Appeal Decision

Appeal Ref: APP/R5510/D/23/3332004

8 Phelps Way, Hayes UB3 4LH

- The appeal is made under section 78 of the Town and Country Planning Act 1990 against a refusal to grant planning permission.
- The appeal is made by Mrs Kulwinder Kaur against the decision of the council of the London Borough of Hillingdon.
- The application Ref 28798/APP/2023/1896, dated 28 June 2023, was refused by notice dated 15 August 2023.
- The development proposed is single storey rear extension.

REVISION: A	REVISED DRAWINGS
PROJECT:	8 Phelps Way Hayes UB3 4LH
DRAWING:	Proposed Floor Plans
SCALE:	1:100. @A3
DATE:	MARCH 2023
PAGE NO:	8 / P / 2023 - 4
STATUS:	PLANNING DRAWINGS

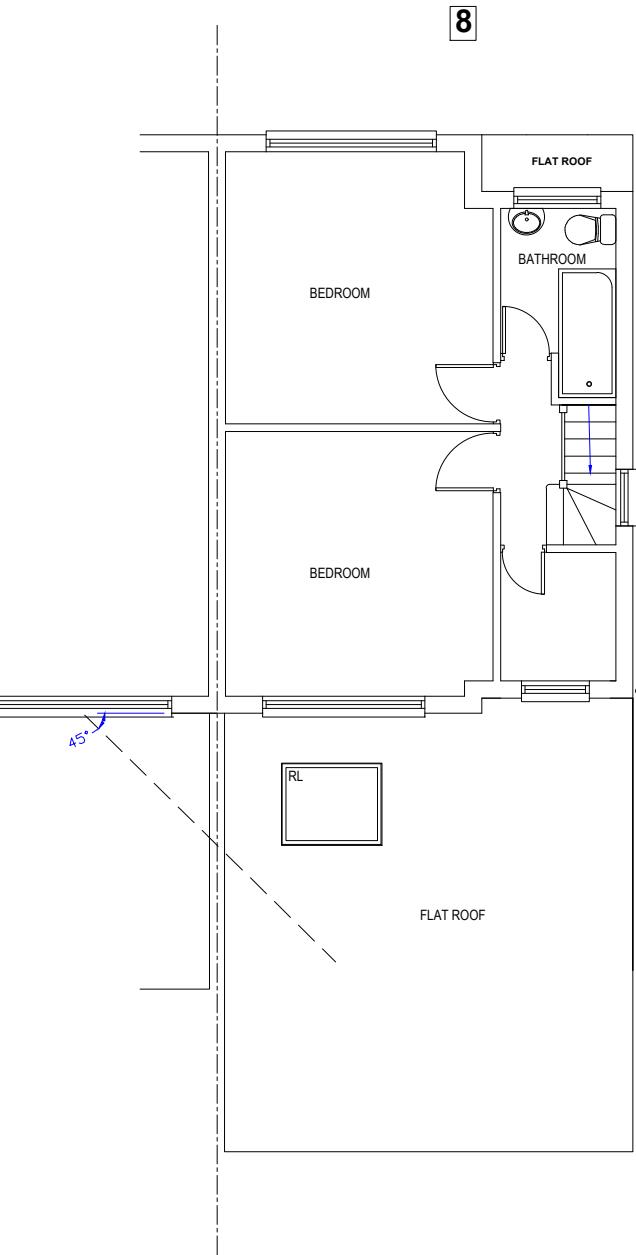
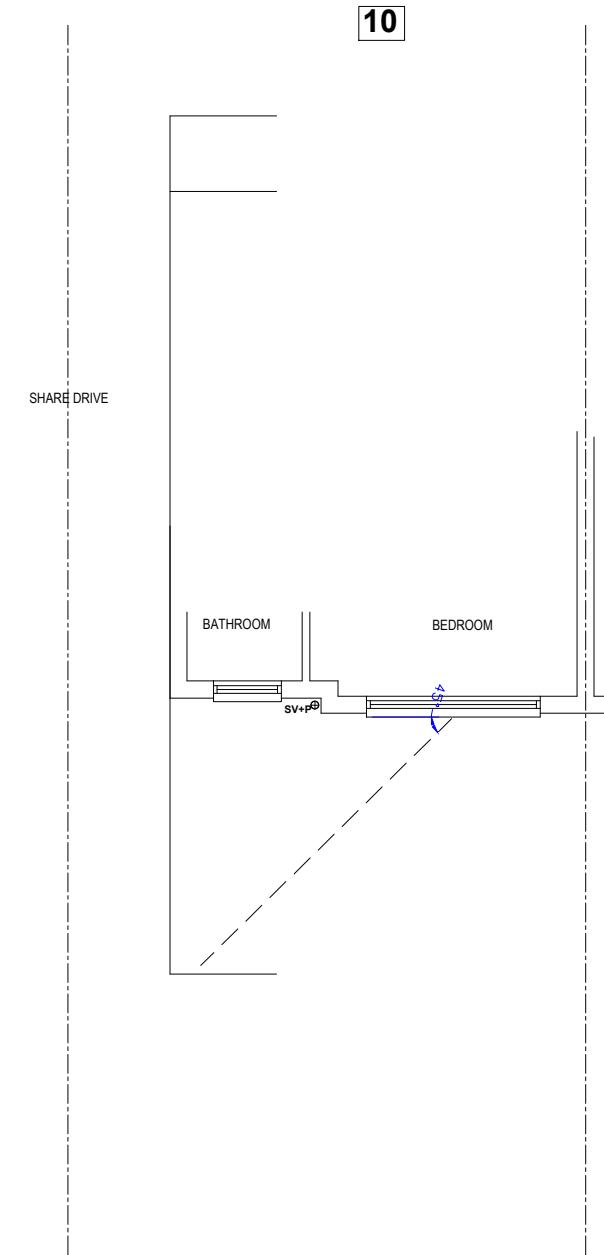
9. The proposals would extend 6m into the rear garden from the back wall of the host dwelling, well beyond those of neighbouring properties and would, in my view, dwarf the host dwelling and appear disproportionate and incongruous. I consider the proposed extension would therefore result harm to the character of the host dwelling as well as the wider area.

11. Given the scale and massing of the proposals I consider this would result in harm to the character and appearance of the area, and the host dwelling contrary to policies BE1 of the LP2 and DMHB 11, DMHB 12 and DMHD1 of the LP2.
